10 January 2019

Town & Country Planning Act 1990 (as amended)
Town and Country Planning (Development Management Procedure) (England) Order 2015
Approval of details reserved by condition imposed under FG/39/18/PL relating to conditions 3-
surface water drainage, 4-ground contamination risk, 9-position & intensity of lighting filaments, 14-
lighting scheme, 15-Construction Management Plan & 16-ground contamination risk.
Garage Premises Littlehampton Road, Ferring,

Arun District Council have decided to **REFUSE details reserved by condition for the following reasons:**

Title **Drainage Layout**

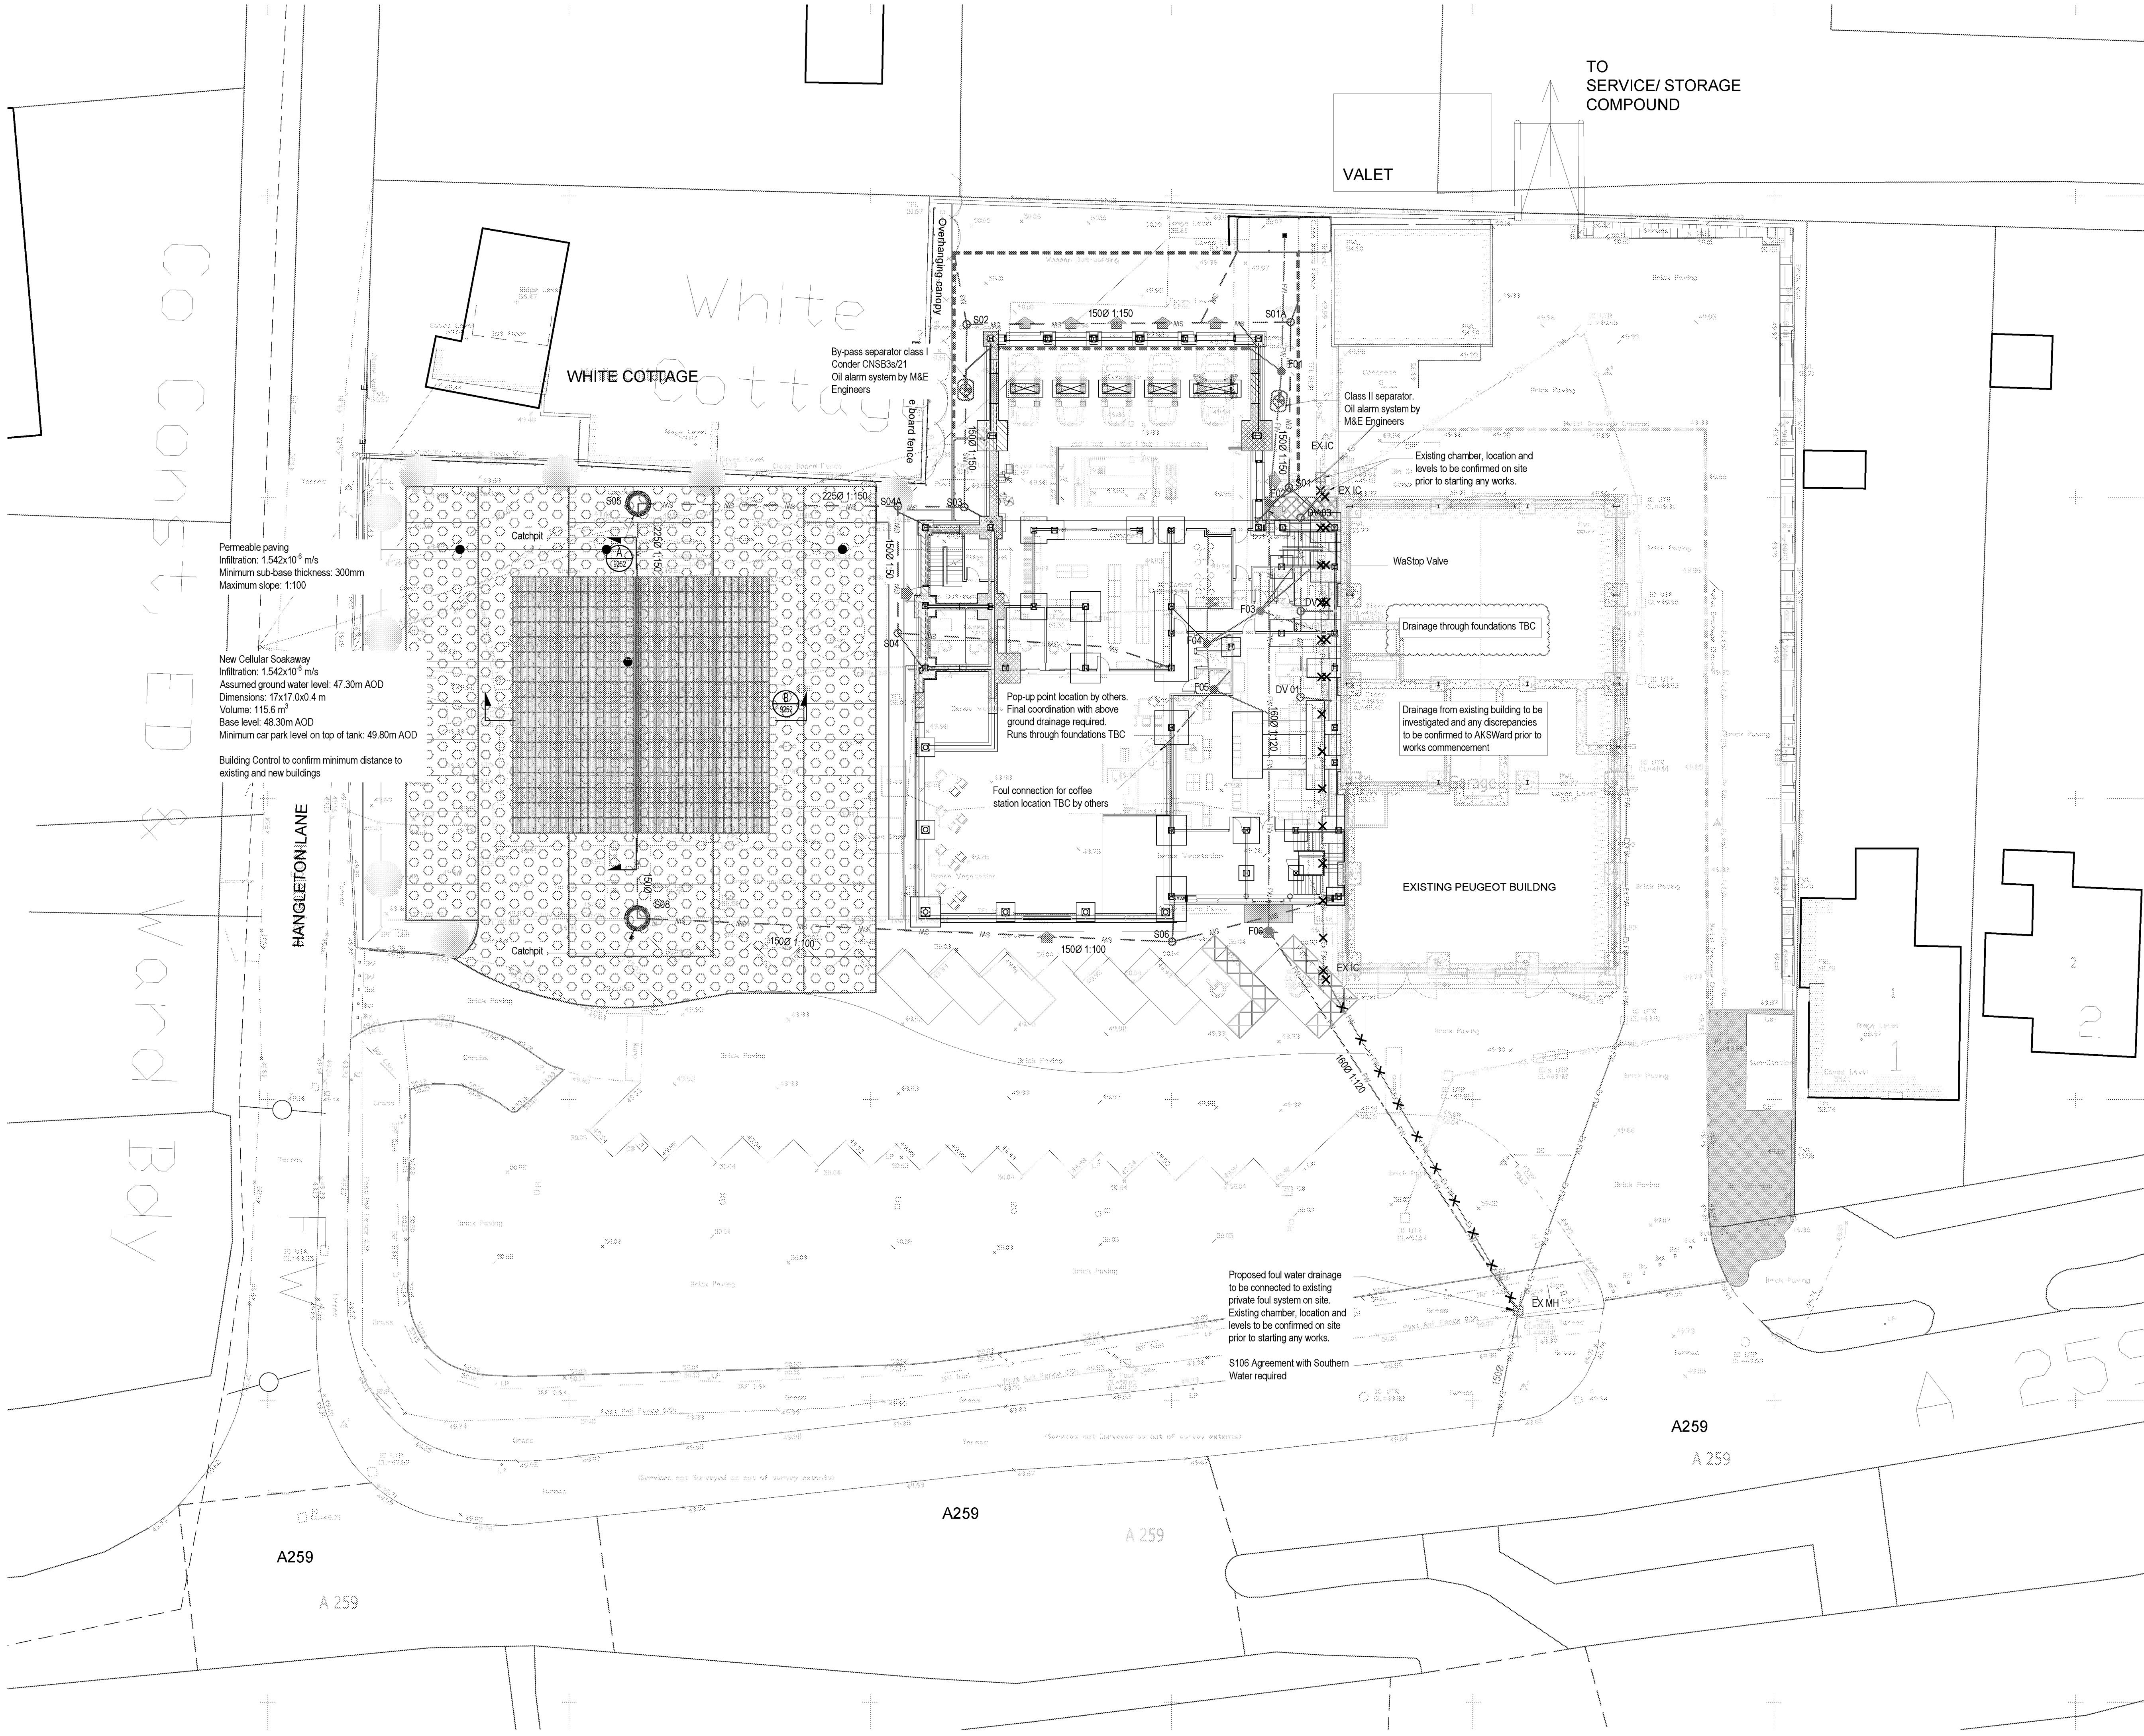
- No winter groundwater monitoring data has been supplied.
- It is also not evident when the infiltration testing was completed. This must be completed in the winter.
- Furthermore, the surface water design is inadequate with the 1 in 100 year plus climate docdeci

change event not stored below ground. The drainage must have capacity in the system to contain below ground level the 1 in 100 year event plus 40% on stored volumes.

- Exceedance flow rates need to be demonstrated.
- Construction detail drawings supplied.
